**RESPONSE TO SUBMISSIONS - MOD 6 TO MP08_0238
1 DENISON STREET, NORTH SYDNEY**

We write on behalf of Winten Property Group (Winten) in regards to the Section 75W modification application being MOD 6 to Project Approval MP08_0238 relating to the construction of a new commercial building at 1 Denison Street, North Sydney.

1 Denison Street, North Sydney (MOD 6)

Response to Submissions

1 Denison Street
North Sydney, NSW 2060
General Arrangement Plan
Basement 04 - Parking

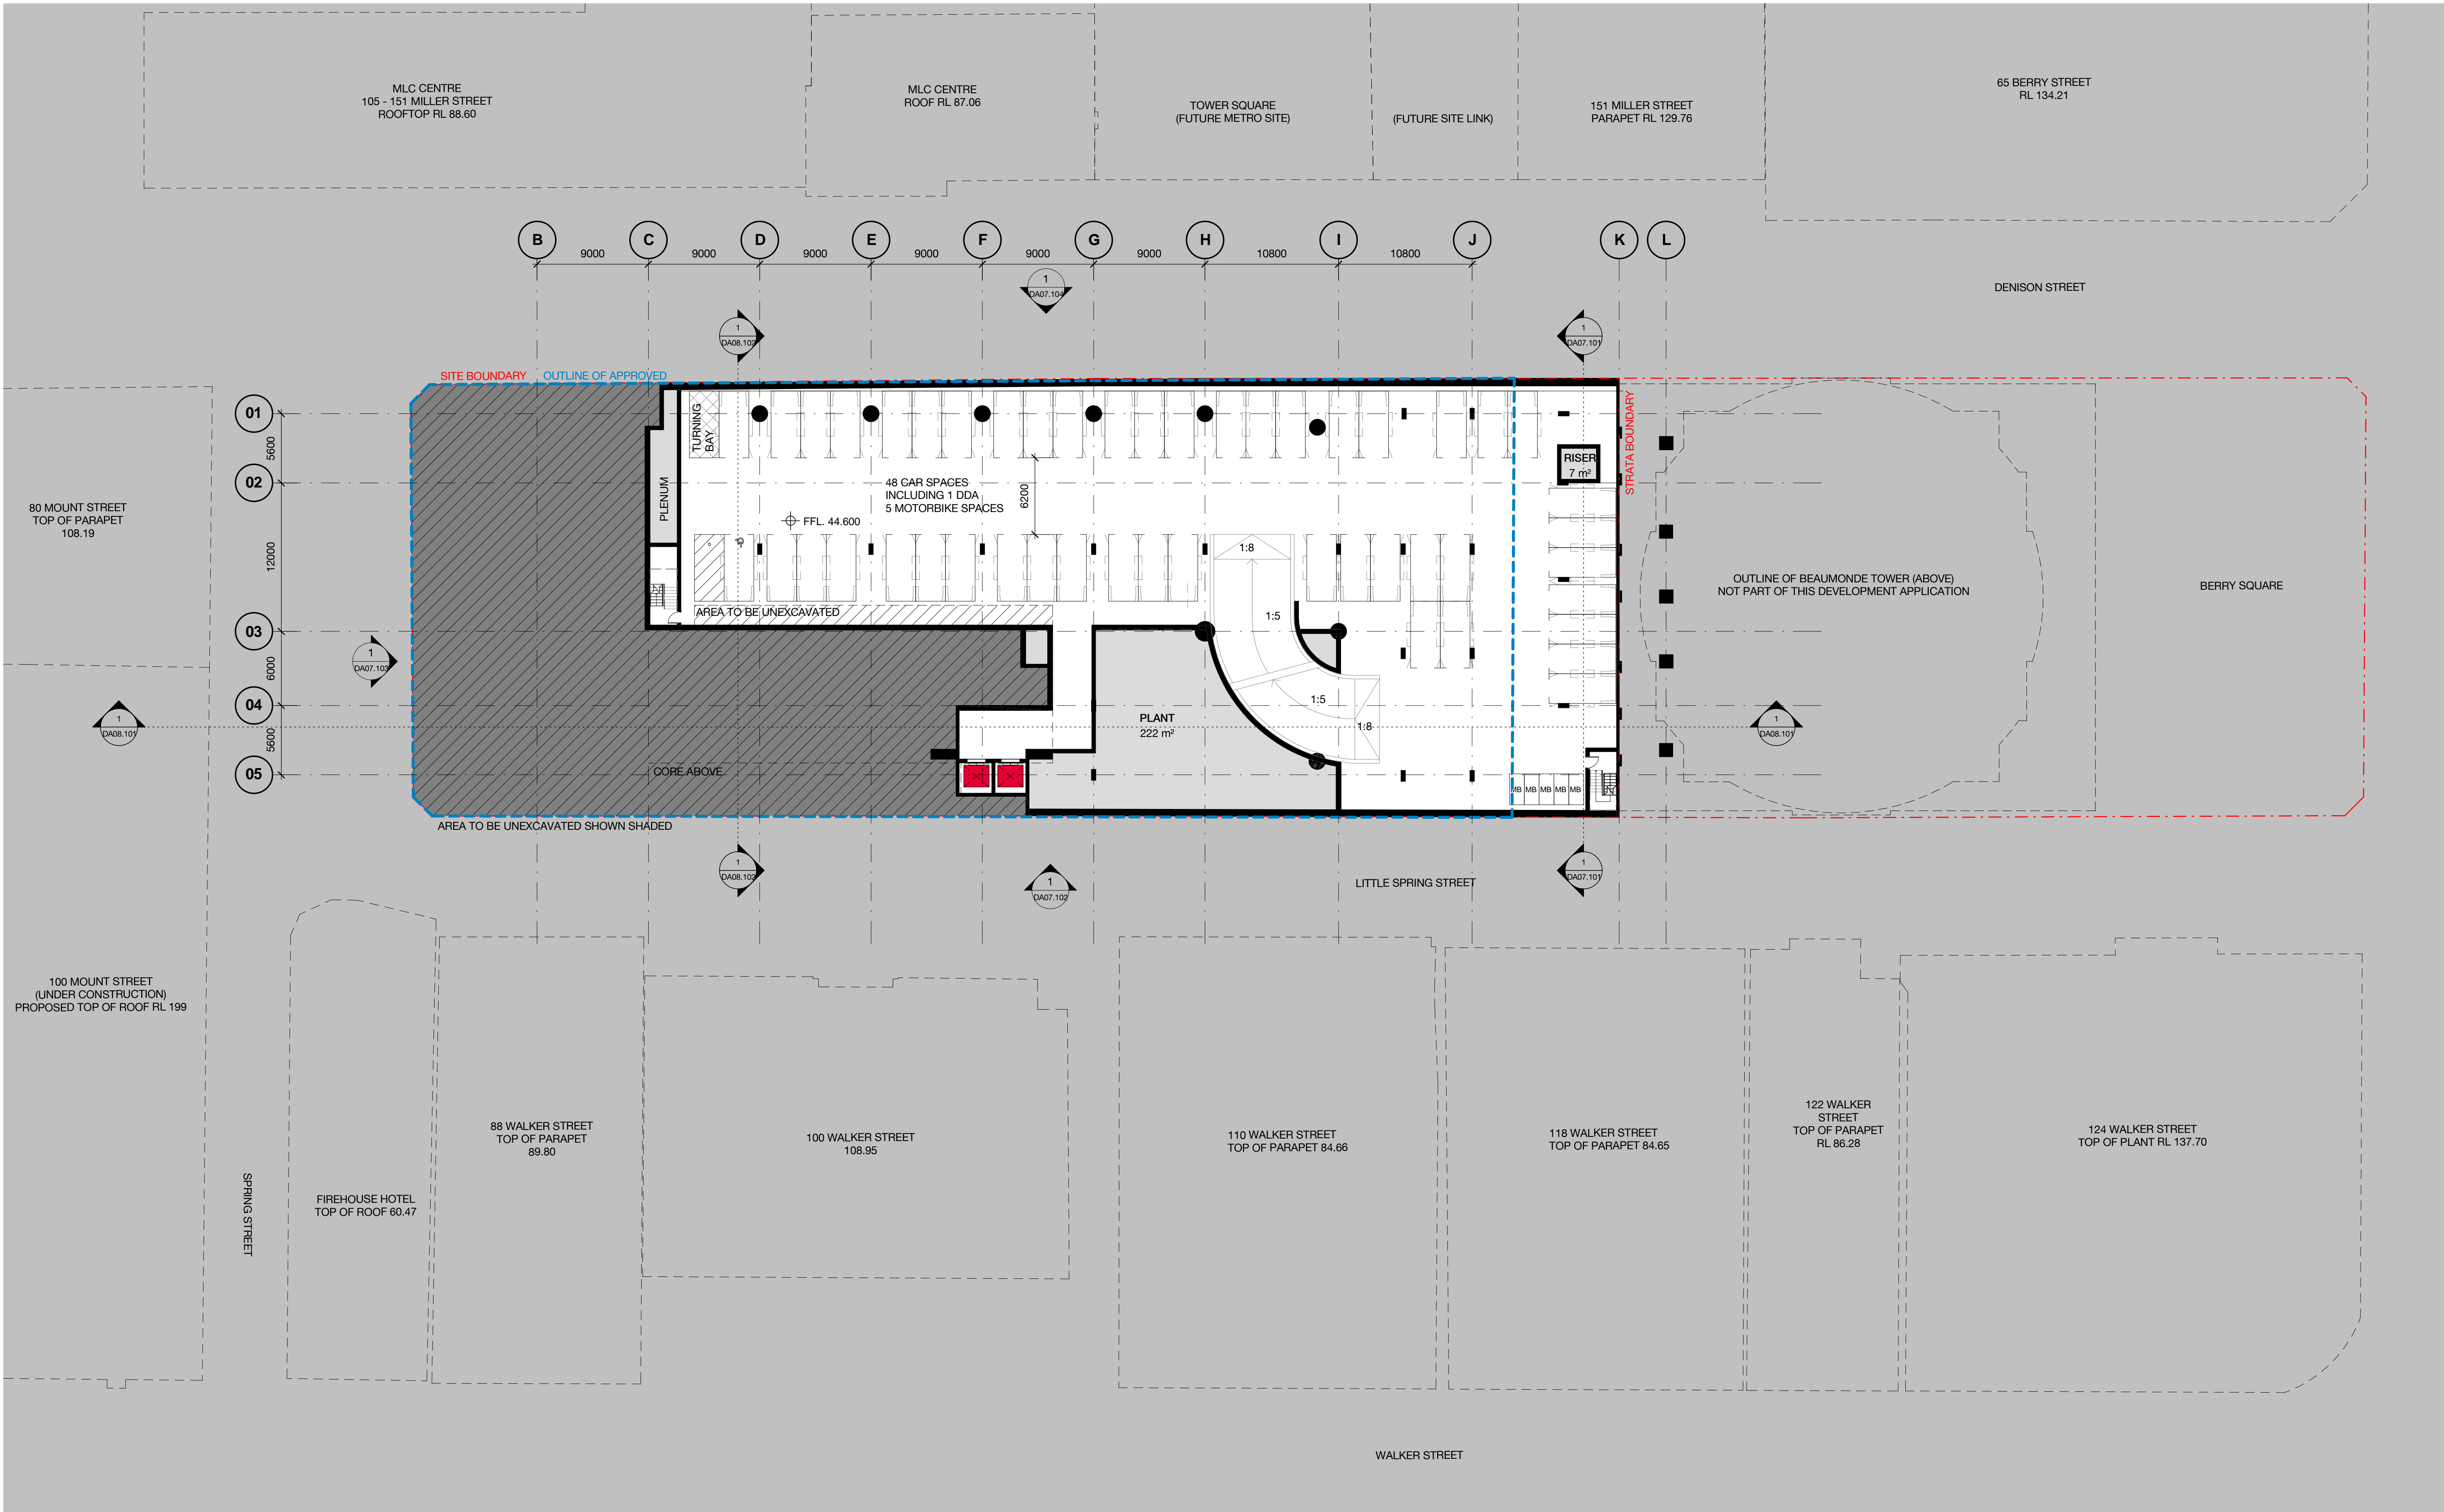
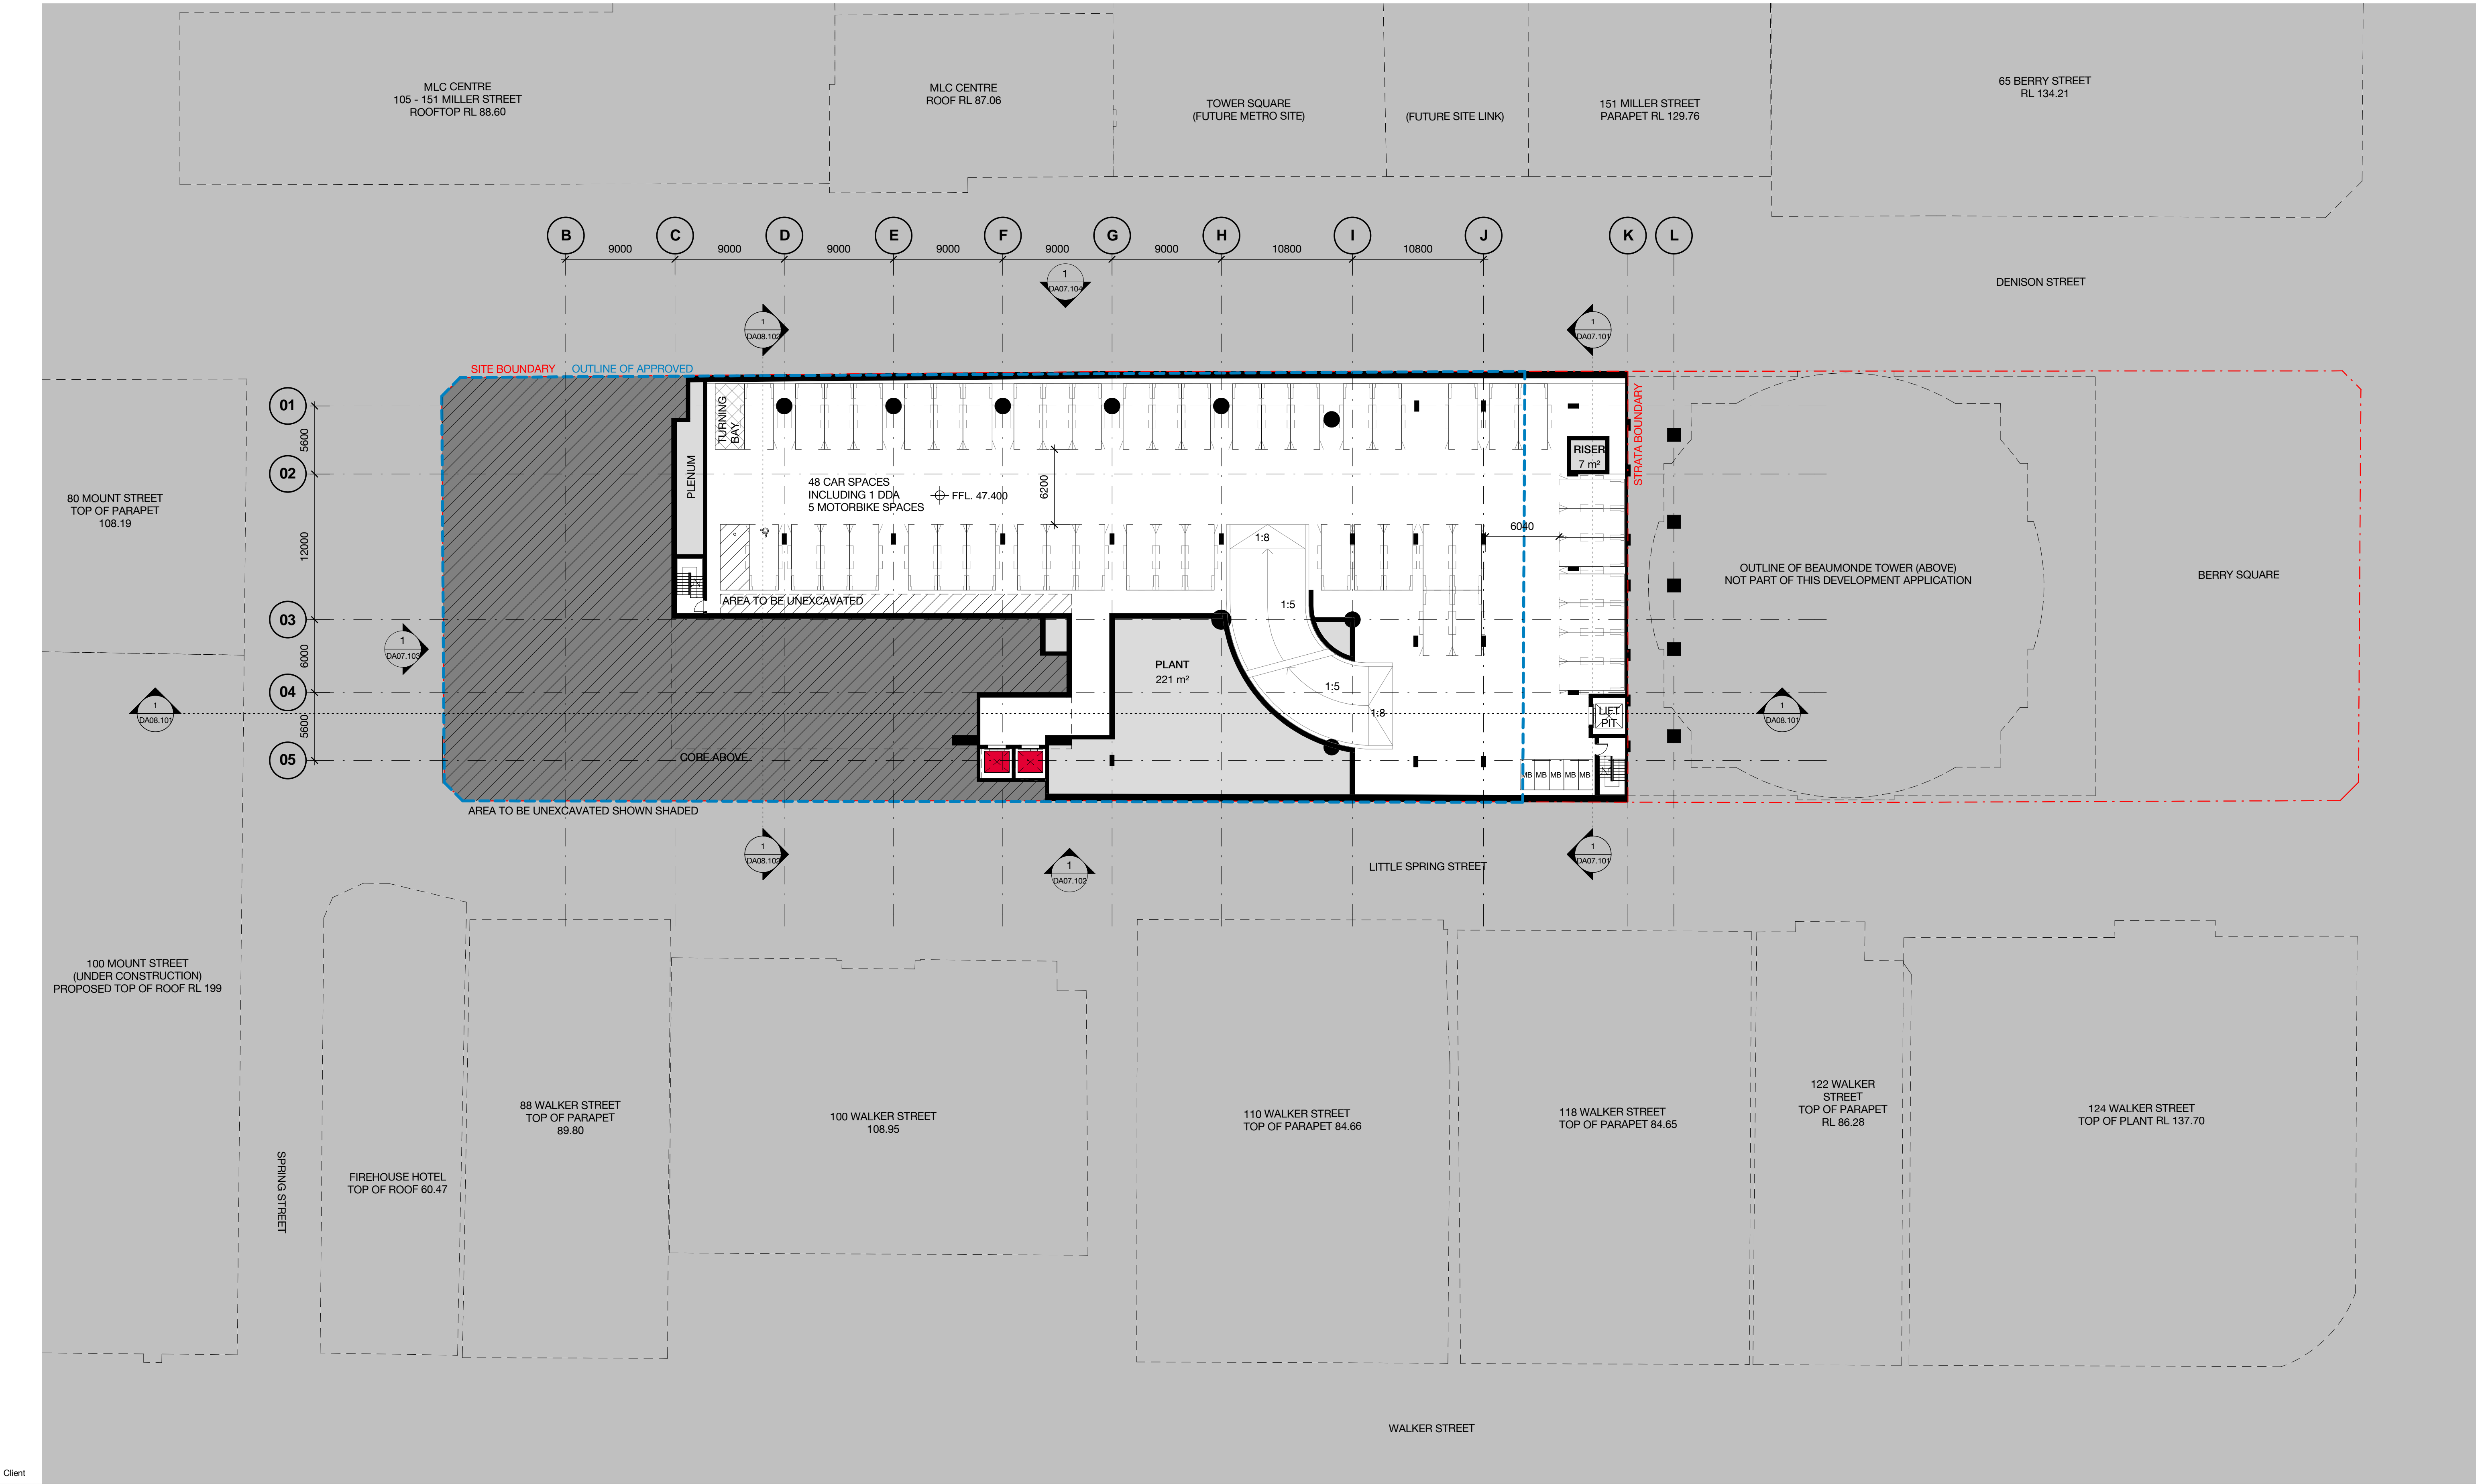
The amended plans (**Attachment B**) reinstate 32 public car parking spaces in response to the submission on behalf of North Sydney Council (Council). These public car spaces, in addition to the 10 car share places proposed as part of MOD 6, will provide a total of 42 car spaces for public use, consistent with the original approval of MP08_0238. The proposed public car spaces will be retained in ownership by the developer and managed as a public car park.

<p>The Department of Planning and Environment may be advised that Council:</p> <ol style="list-style-type: none"> Does not support the previously approved 22 space public car park on site being replaced by car share parking and tenant parking. Does not agree to the loss of 40 on street car spaces without an appropriate offset being provided for onsite, Seeks reinstatement of the public parking to offset the loss of on street parking for a minimum of 40 spaces. 	Following further discussions with Council in light of its submission, the proposed development has been amended to include 10 car share spaces and 32 public car spaces – totalling the 42 spaces originally approved. The ownership and management of these public car park spaces will be retained by the proponent.
The Department of Planning and Environment be advised that the under-provision of bicycle parking, particularly for a significant commercial development in the heart of the North Sydney CBD, will undermine the intent of Council's DCP and transport policies.	The provision of bicycle parking has been increased from 220 to 570 and will be provided at the rate consistent with the requirements of 5-star Green Star rating. Whilst the proposed provision remains under Council's requirement of 710 spaces, 5-star Green Star is classified as Australian best practice sustainability, and therefore it is considered unreasonable to request a provision of bicycle spaces in excess of this standard. We also note that this is a substantial increase from the approved bicycle parking of 161 spaces.

A revised Traffic and Parking Assessment, prepared by Arup and submitted at **Attachment C**, confirms that the changes to the basement car park and provision of additional public car parking will not generate any measurable impact on the surrounding road network as these public car spaces will provide replacement of existing on street parking lost through the redevelopment of the site. Therefore the revised basement and car parking is considered appropriate for the site. A summary of the revised total car parking provision within the development is provided in **Table 1**.

<i>Condition B43 – Bicycle Storage and Parking</i> Comment: The proposed quantity of bicycle parking is less than half the minimum required under Council's DCP. The rates set in the DCP were a deliberate policy decision by Council to encourage the use of bicycles as an environmentally beneficial form of transport and an alternative to the use of private motor vehicles. The under-provision of bicycle parking by 60%, particularly for a significant commercial development in the heart of the North Sydney CBD, will undermine the intent of the DCP and Council's transport policies. The Department is requested to insist on additional bicycle parking.	The proposed provision of bicycle parking has been increased from 220 to 570 and will be provided at the rate consistent with the requirements of 5-star Green Star rating. Whilst the proposed provision remains under Council's requirement of 710 spaces, 5-star Green Star is classified as Australian best practice sustainability, and therefore it is considered unreasonable to request a provision of bicycle spaces in excess of this standard. We also note that this is a substantial increase from the approved bicycle parking of 161 spaces.

The amended plans (**Attachment B**) include an increase in the provision of bicycle parking in response to the submission of Council. The provision of bicycle parking has been increased to meet the requirements of 5-star Green Star building rating, providing a total of 570 bicycle spaces, including end of trip facilities, as detailed in the amended plans. Although the proposed bicycle parking remains non-compliant North Sydney Development Control Plan provision; 5-star Green Star is considered the industry best practice standard and therefore considered the most appropriate standard for the development. Further, the increased provisions represents an additional 409 spaces to that of the approved development (refer to **Table 2**). It is noted that should demand for the bicycle spaces increase above provision in the future then car spaces within the tenant car park could be converted to additional bicycle spaces.
